Application for a Non-Material Amendment Following a Grant of Planning Permission

NMA 1, three changes requested:

22/0303/FUL

date	desc	status
Jan 22	unit 2 elevations	PLANNING
drawn kbl	client Mr K Smith	add Winchester Avenue, Blaby, Leicester LE8 4GZ
Scale 1:100@A1	job no 21-119	dwg no B002
		rev B

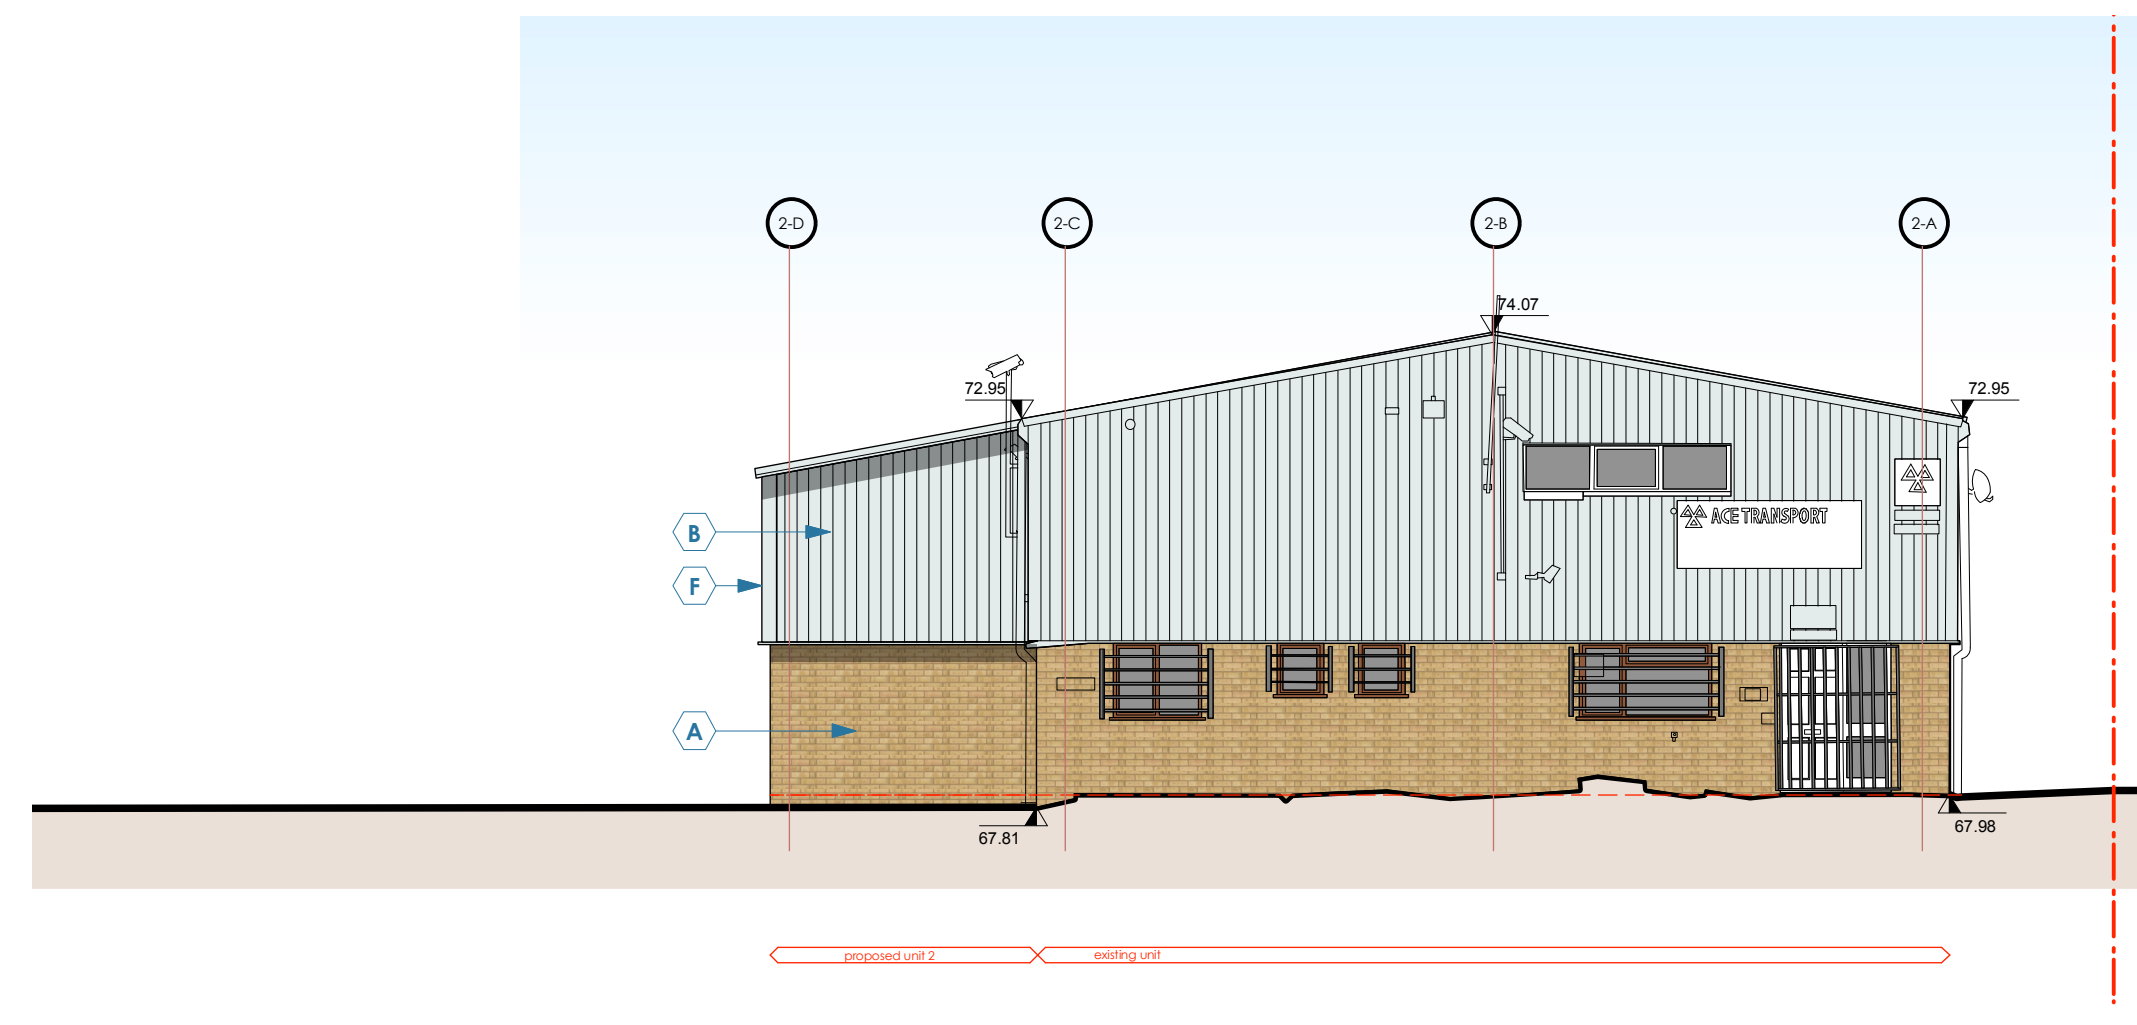
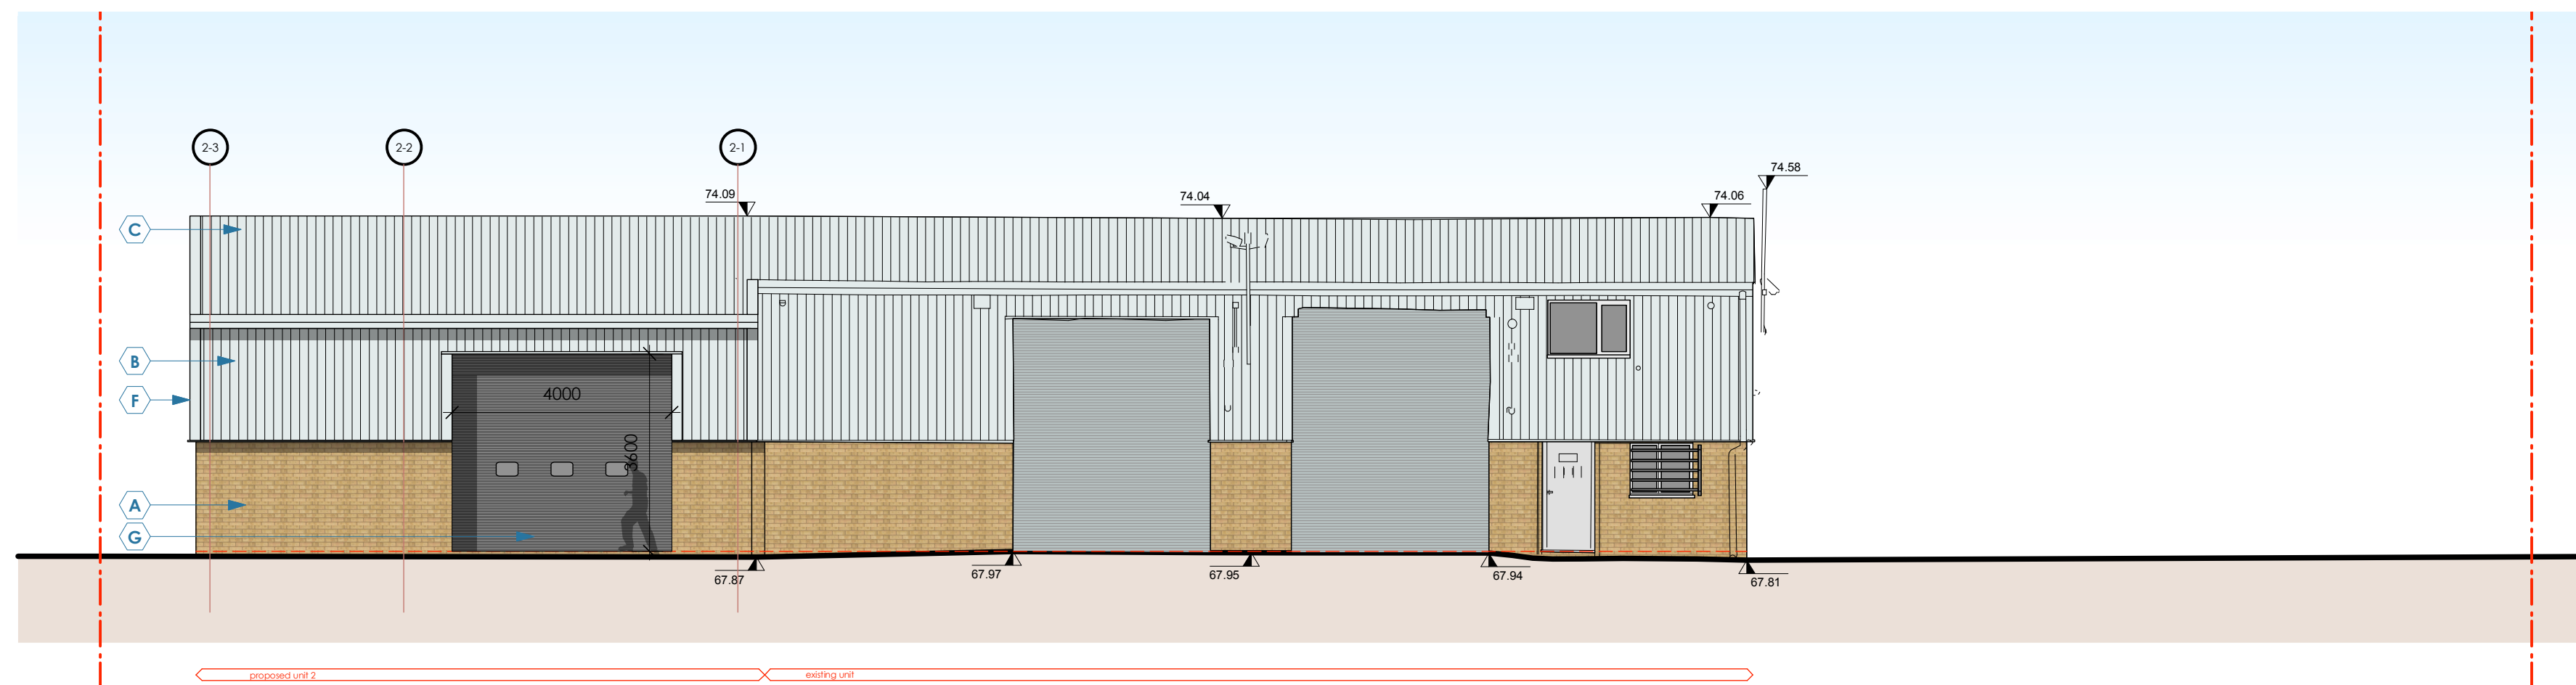
- Cladding colour change
- Unit 2 door change
- Unit 3 & 4 rear elevation material change

All units - cladding colour change from RAL 9006 Silver to RAL 7038 Light Grey
Unit 2 Entrance door change from curtain walling to Steel Dorset
Unit 3 & 4 - rear elevation change from brickwork to fair face blockwork.
